CITY OF ALBUQUERQUE

February 27, 2019

**RE: Los Pastores Shopping Center
Montgomery/Wyoming
DMP Addendum
Engineers Stamp Date: 2/11/2019,
Hydrology File: F19D013C**

Based on the information provided in your submittal received on 2/11/2019 the DMP Addendum cannot be approved until the following comments are addressed.

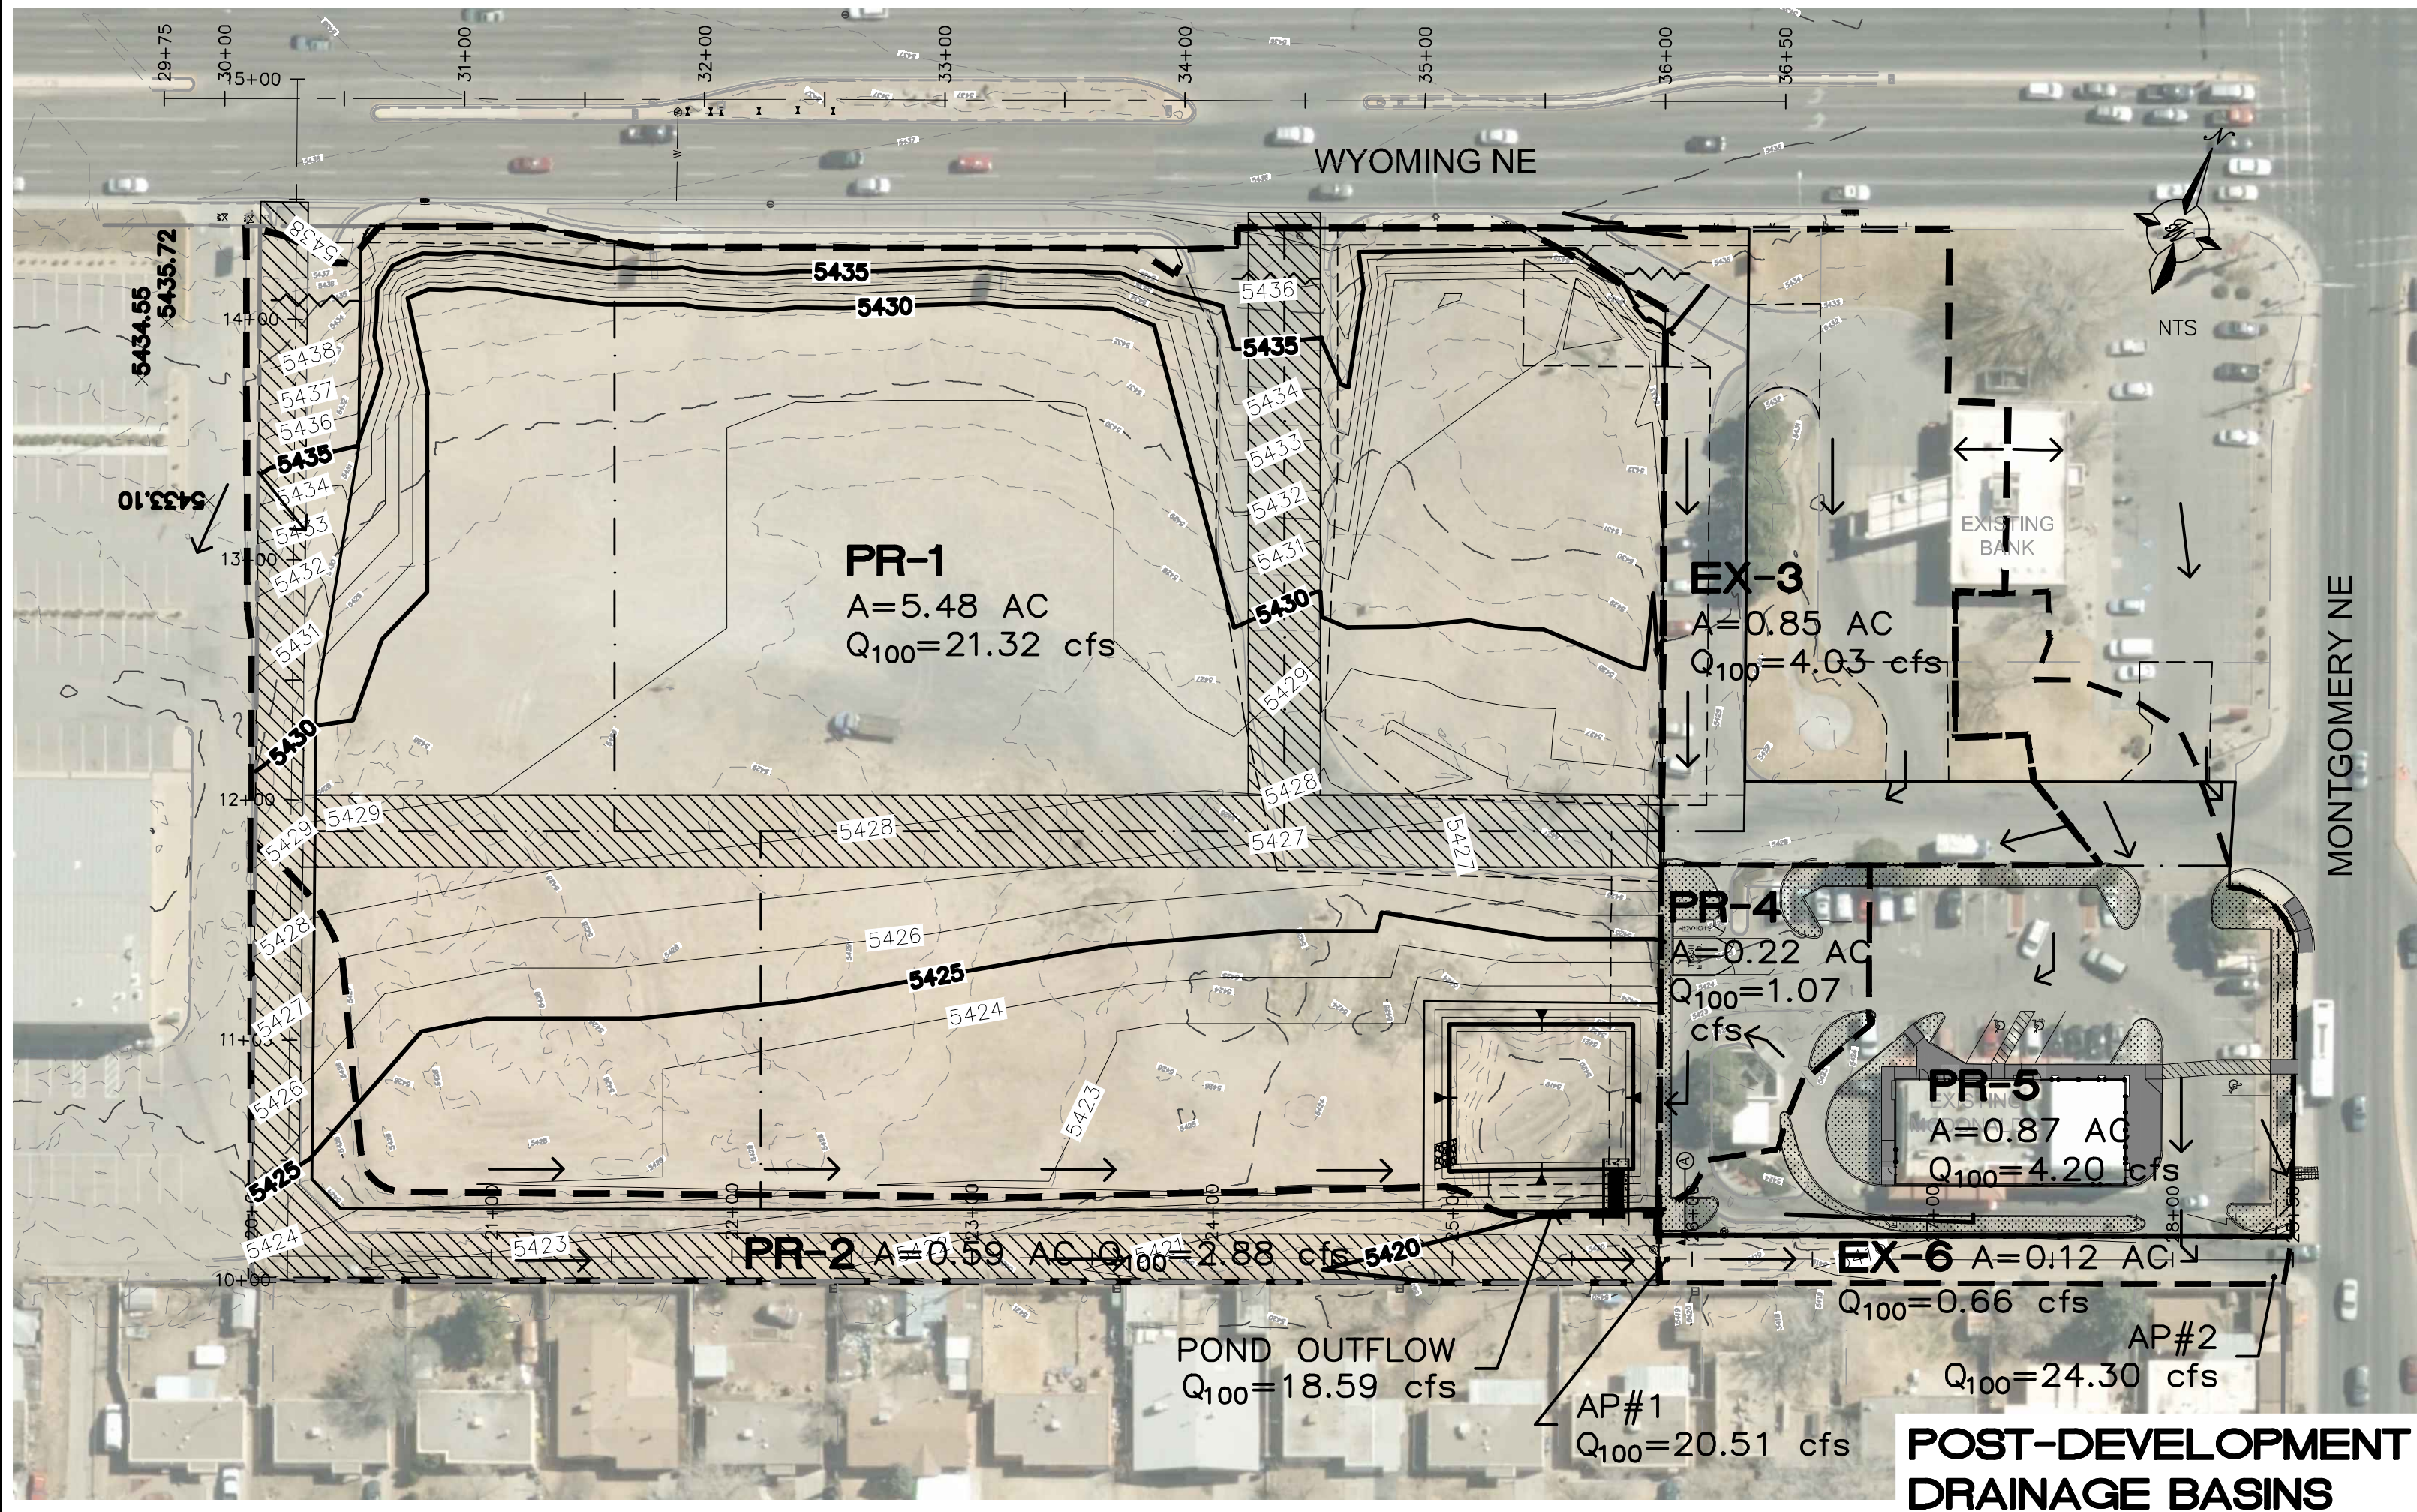
6. The new McDonalds layout needs to be shown on the Post-Development Basin Map. The basins on this plan must agree with the separate plans being prepared for the McDonalds building permit.

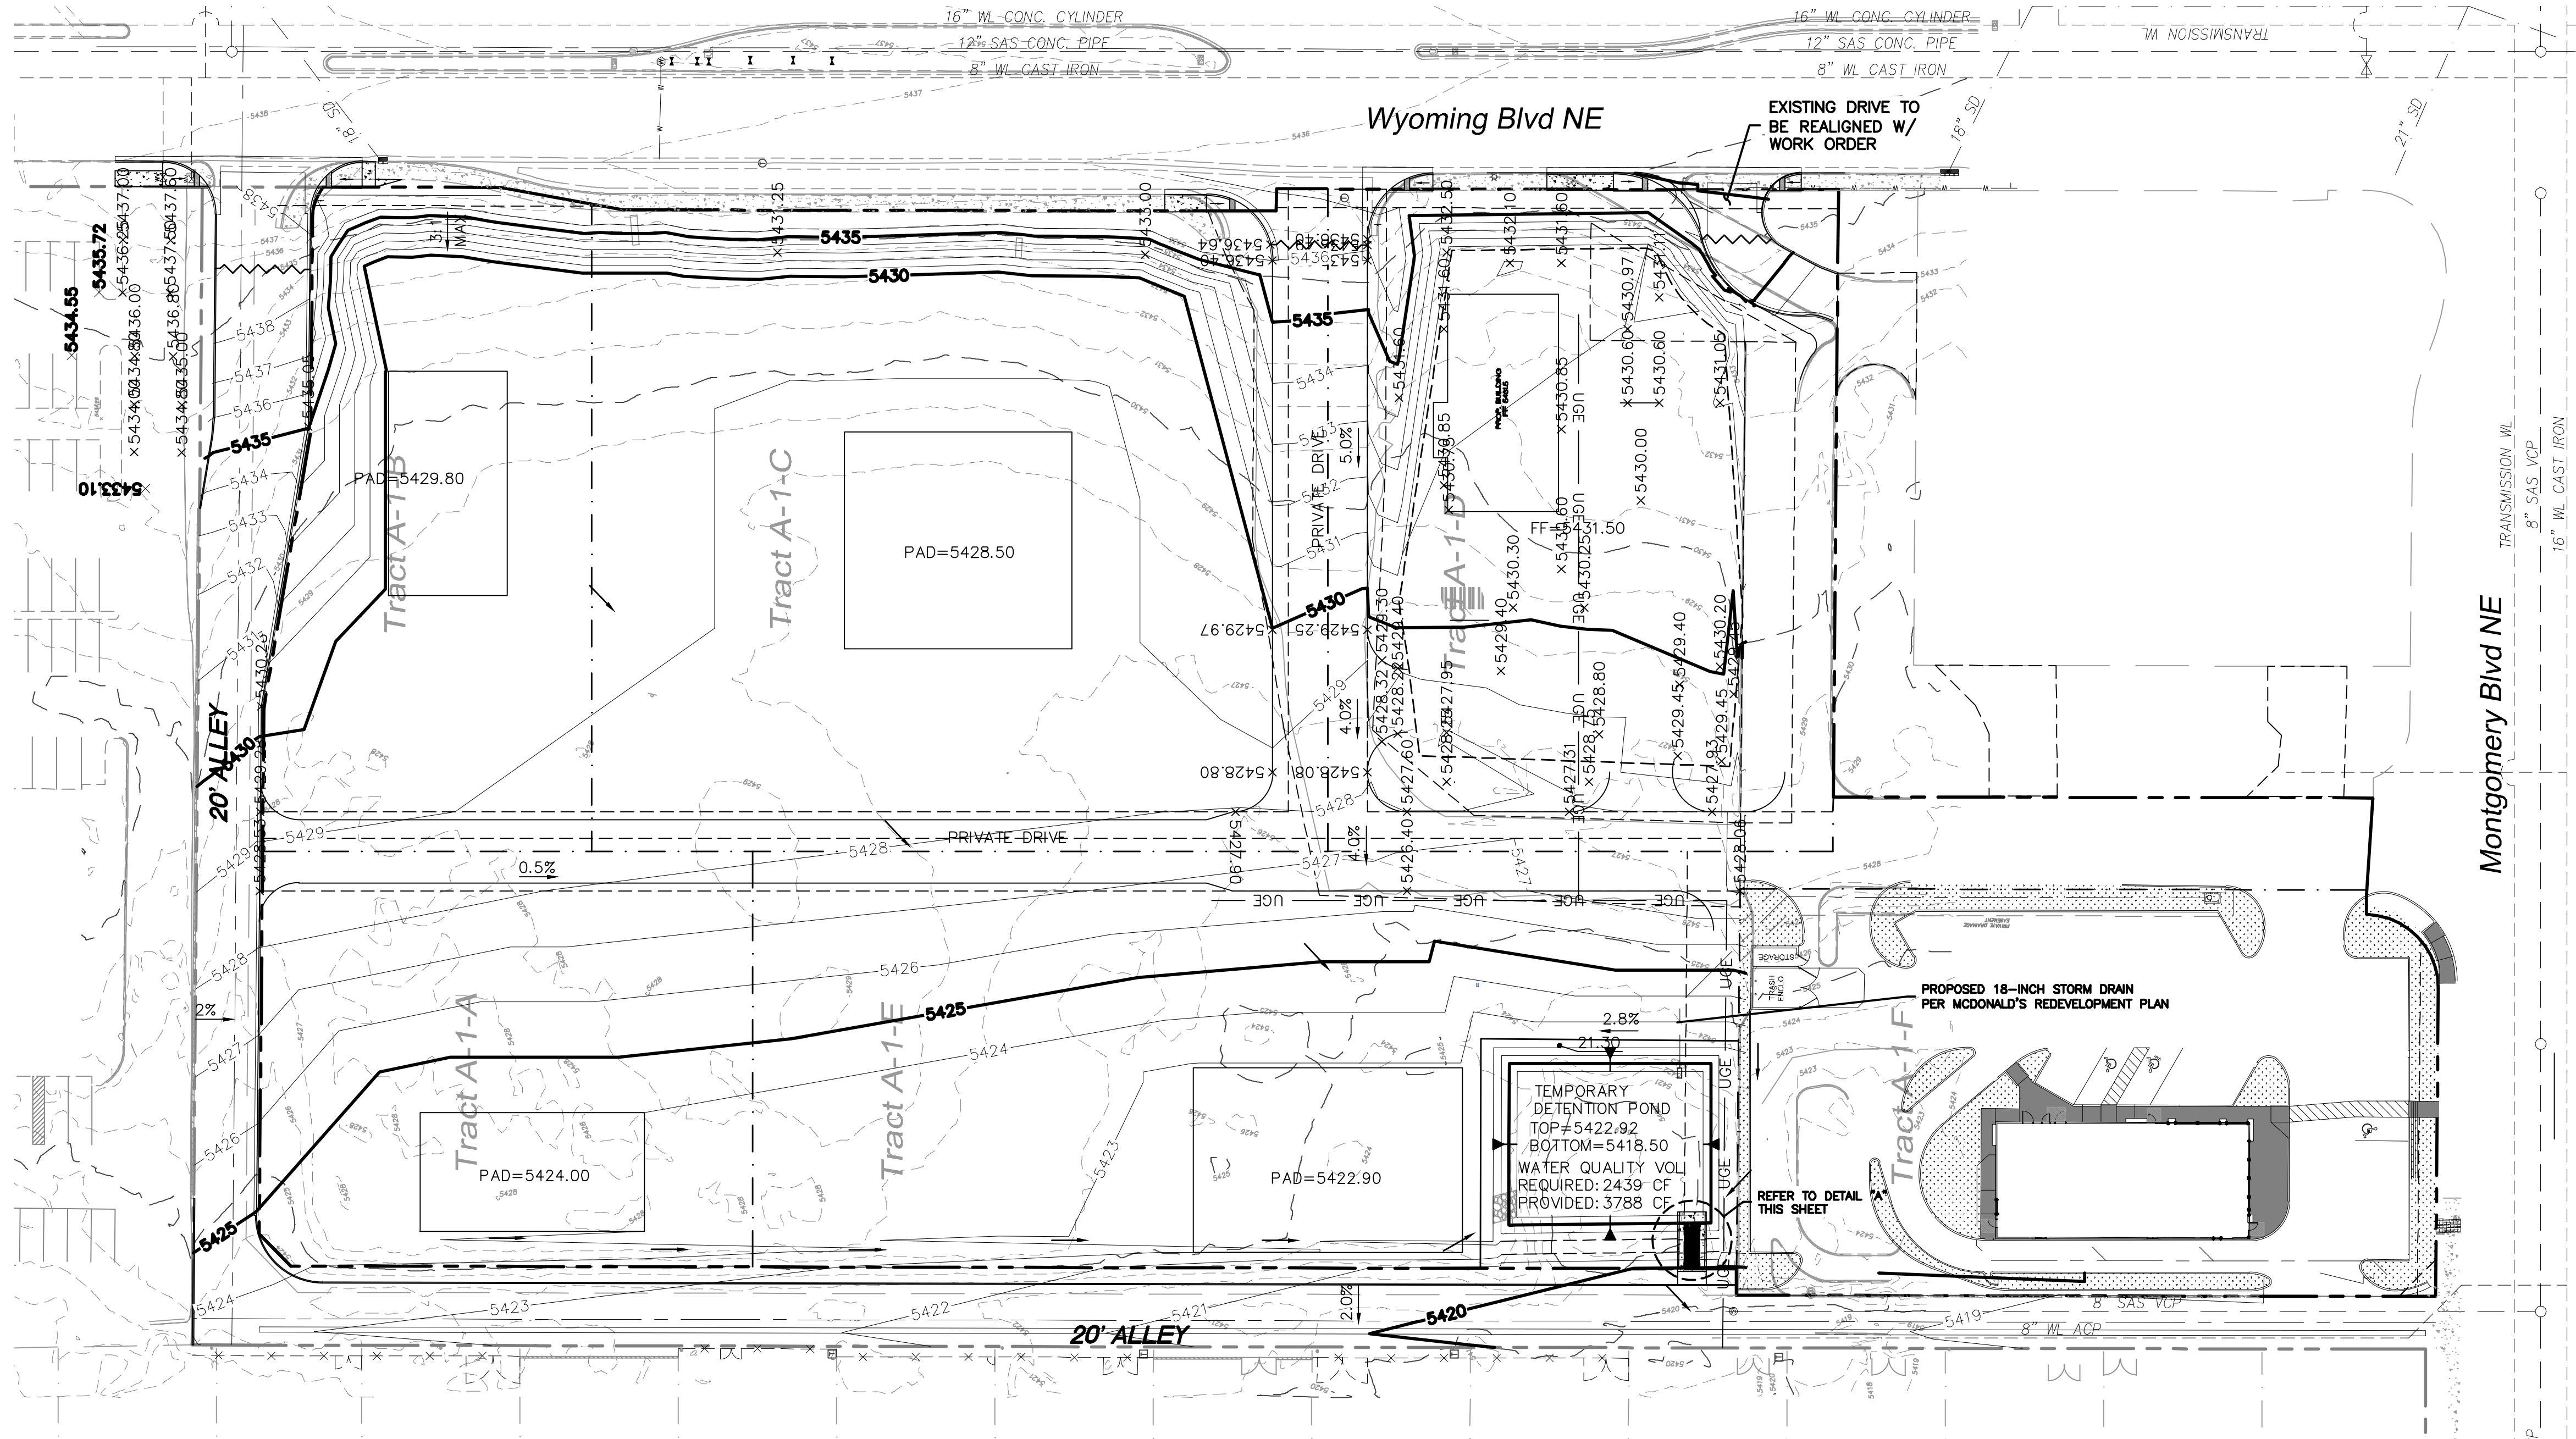
4. Details of the pond outfall structure and pond grading must be included in the addendum including the new storm drain from the McDonalds.
5. Basin 5 should be separated into two basins, onsite and offsite. Additional analysis points are needed.

14. The Storm water Quality volume calculations need to be on the pond detail in the addendum and in the covenant.
15. An updated Engineer’s Certification of the Los Pastores Pond will be required prior to Certificate of Occupancy for the McDonald’s, and may be included in the addendum if no new pond construction is needed.
